City of Albuquerque Stormwater Construction Site Inspection Report

Project Name and Location	Campbell Compound 2240 Campbell Road		
Site Contact Name & Agency	Scott Ashcraft Las Ventanas Homes	ESC File No. NPDES ID No.	G13E032 NMR1001ZW
Date of Inspection	11/01/18	Start/End Time	2.45pm 3:05pm
COA Inspector Name	Cassandra Durkin, Stormwater Quality		
Describe Present Phase of Construction	Streets Constructed, Pads Graded, Constructing Walls		
Type of Inspection:			
<input checked="" type="checkbox"/> Regular <input type="checkbox"/> During storm event <input type="checkbox"/> Post-storm event (> 0.25 inch) <input type="checkbox"/> 311 / Complaint Response <input type="checkbox"/> Follow-Up

EROSION AND SEDIMENT CONTROL PLAN

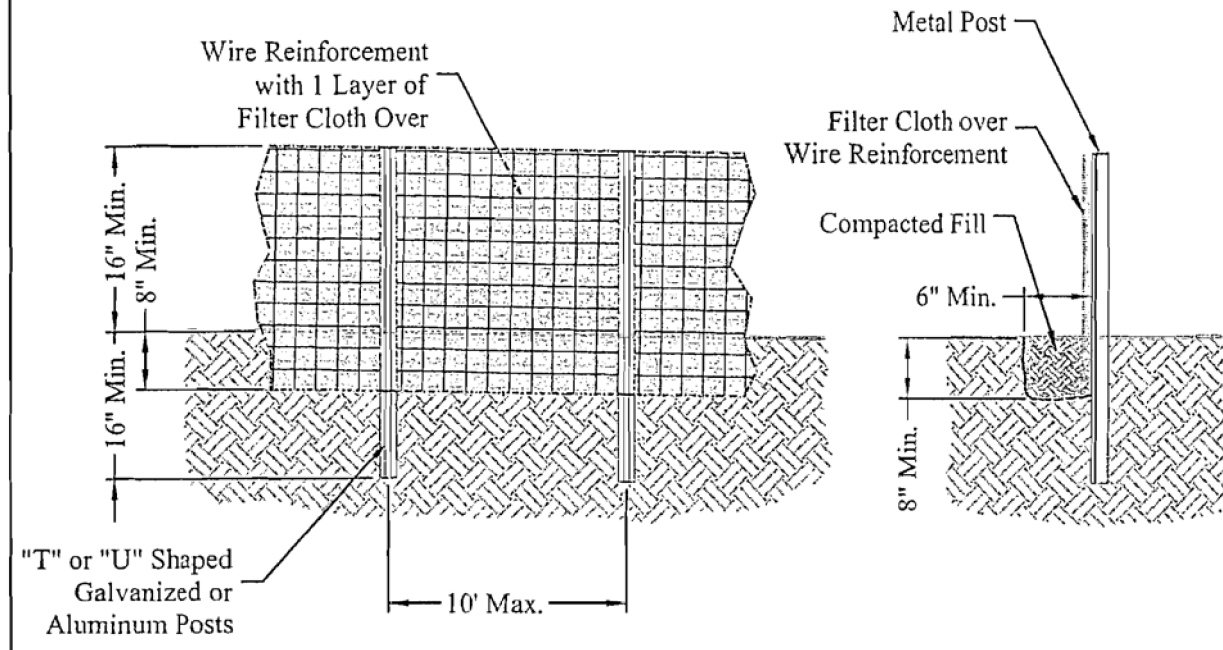
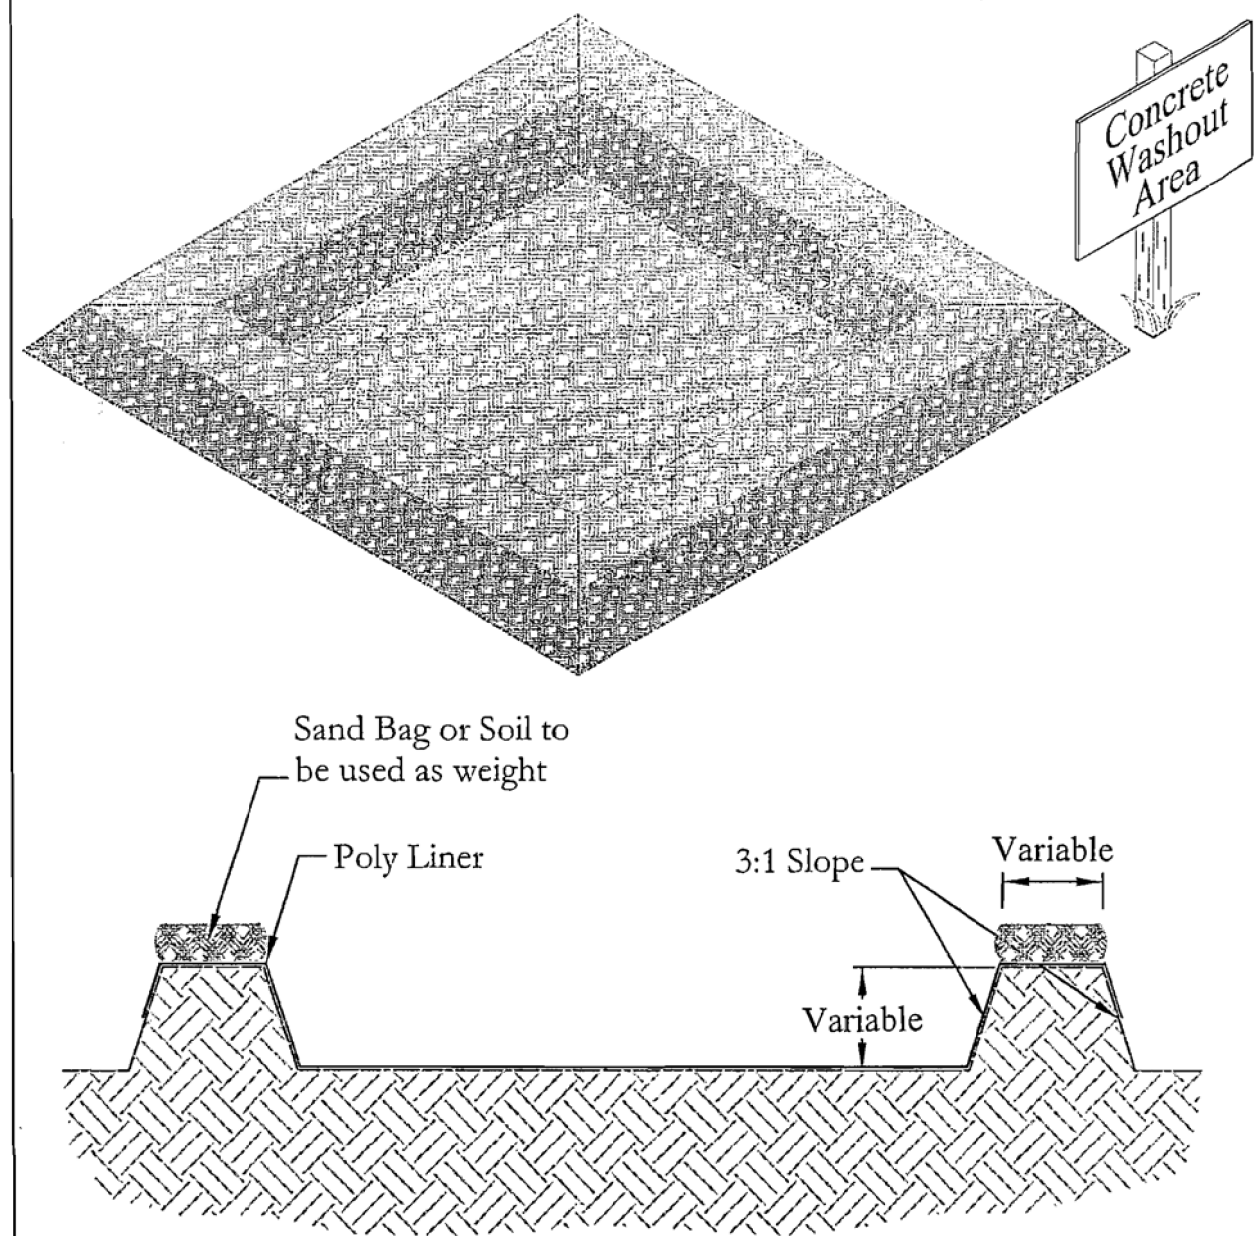
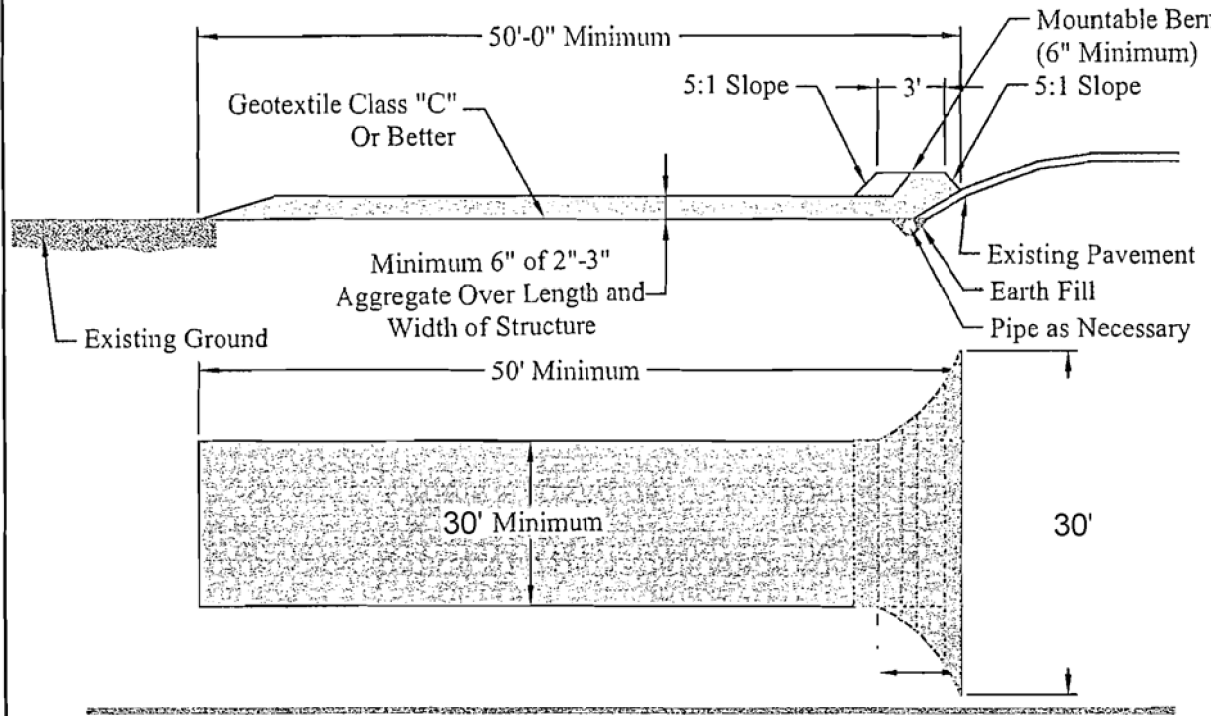
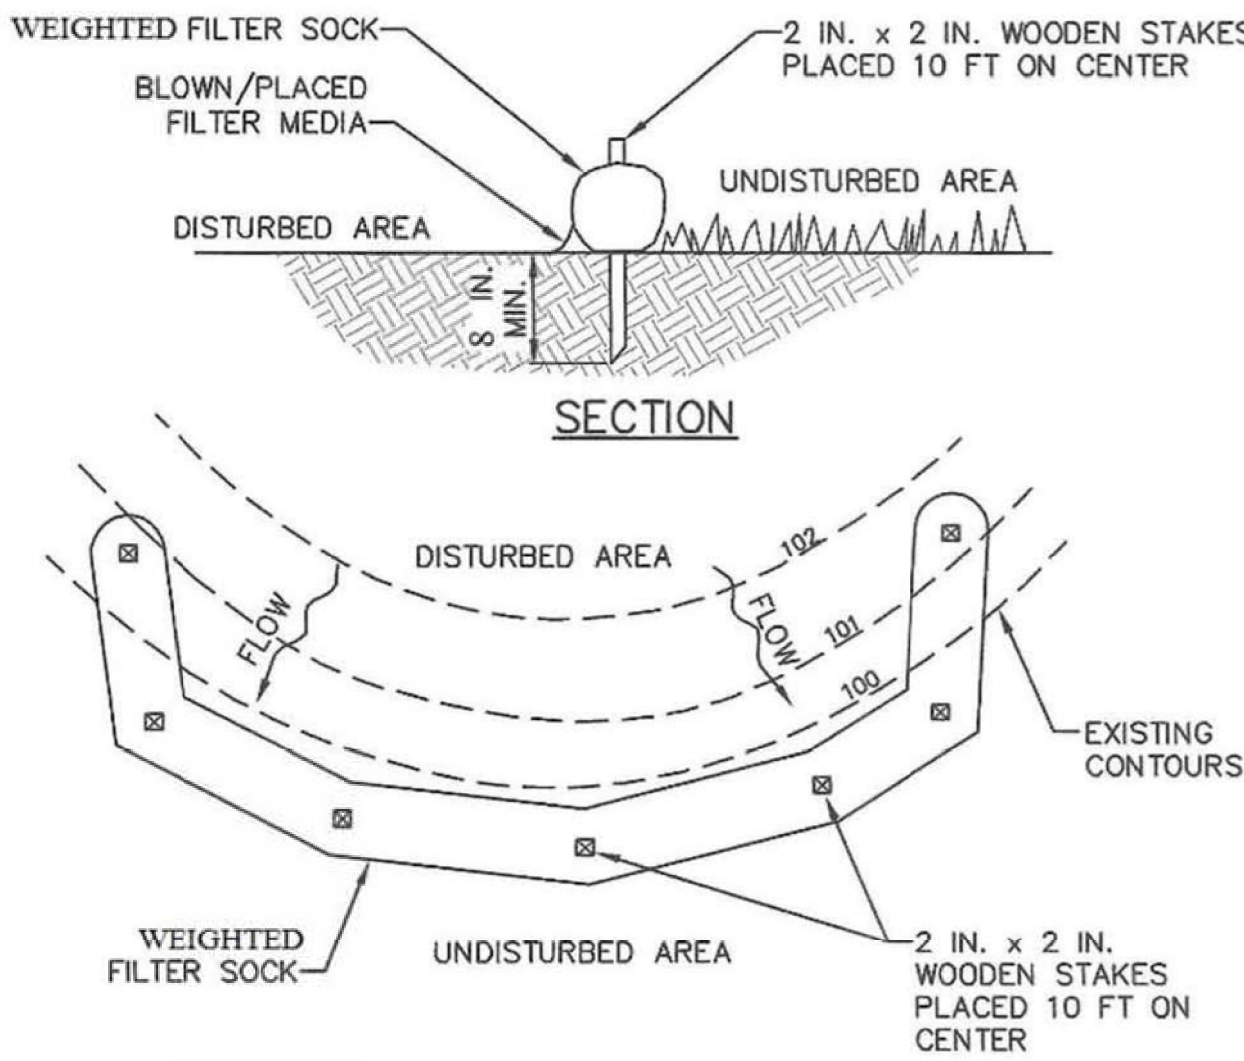
2.3.3	Construction and Domestic Wastes		Yes	No waste container on site
2.3.3	Construction and Domestic Wastes		Yes	Debris Pile
2.3.4	Washing Applicators used for paint, stucco, concrete, etc.		Yes	Washout on dirt is evident

Please address the corrective actions within 7 days. Please email pictures of the corrections and the most recent Inspection Form for your site.
